Date: 06 December 2023
Our ref: 458158
Your ref: 2382/APP/2023/2906

Planning consultation: Redevelopment of the site to create the Hillingdon Watersports Facility and Activity Centre including demolition of existing Broadwater Lake Sailing Club (BSC) clubhouse at the north of the lake and erection of a building and facilities to be occupied by HOAC and BSC

Location: Broadwater Lake, Moorhall Road, Harefield.

OBJECTION

Figure 1.1 The site red line boundary, showing the numbering of islands.

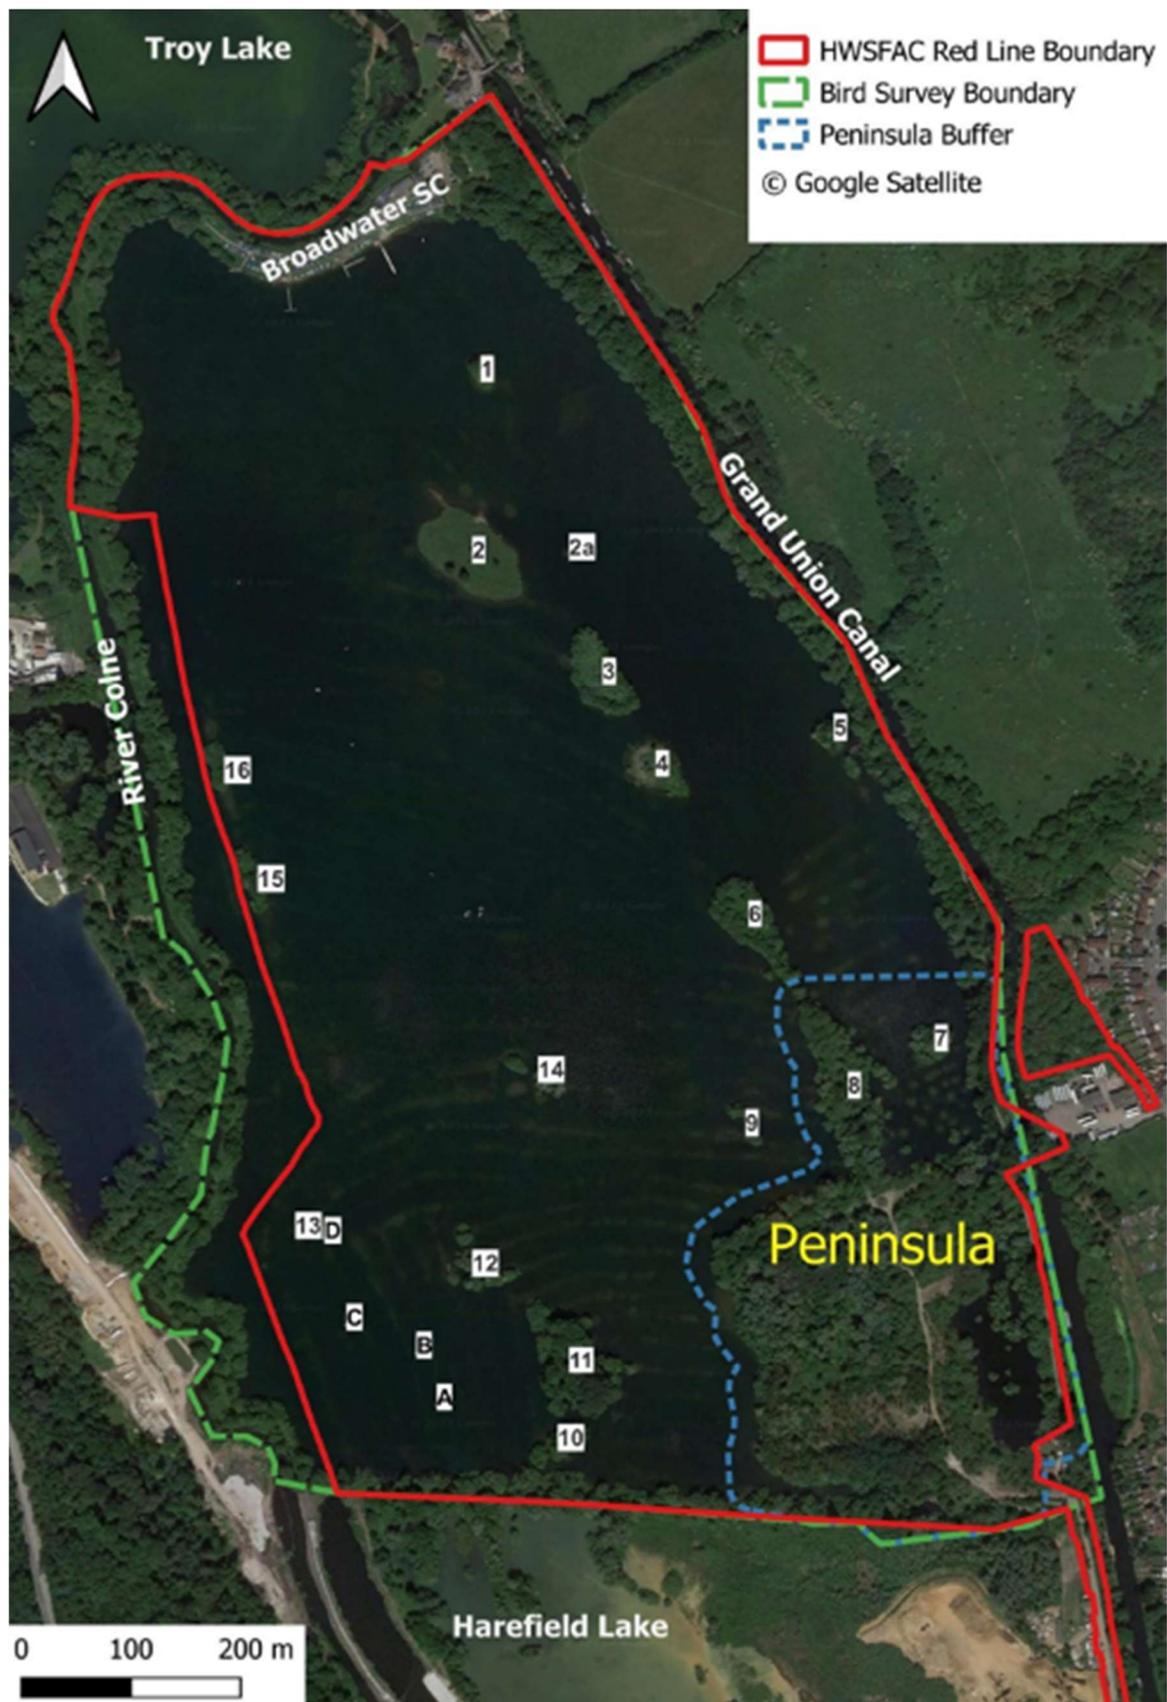
As part of the proposals, multiple islands are being lost from the site. Confirmed in paragraph 7.6.23 in ES Chapter 7 – Biodiversity, the removal of islands 2a and 3 will result in the loss of at least 10 confirmed breeding sites for various bird species. Land reclamation at the peninsula incorporating islands 8 and 9 will result in additional loss of nest sites for breeding birds and a small part of up to 16 territories of 10 species may be lost (paragraph 7.6.24). Natural England note that floating reedbeds and tern rafts have been proposed as mitigation to provide new nest sites. Whilst this will demarcate areas for recreational use and therefore discourage boats and other activities around the islands, Natural England have concerns that this may not provide suitable nesting habitat for the existing bird populations.

The loss of the islands will also have a direct negative impact on aggregations of non-breeding birds. Over-wintering birds may lose up to 10 winter terrestrial roosting sites through the loss of island 9 and this island has been identified as important to tufted duck, a specific over-wintering species for which this site has been designated, and which were regularly recorded as using the islands (7.6.32; 7.6.33). Tree clearance and removal will also reduce the natural screening element provided by these trees to over-wintering birds. Natural England recognise that there are proposals to create new islands as part of the ecological enhancements planned for the development and acknowledge that these would help to mitigate the removal of the existing islands but will not fully offset damage.
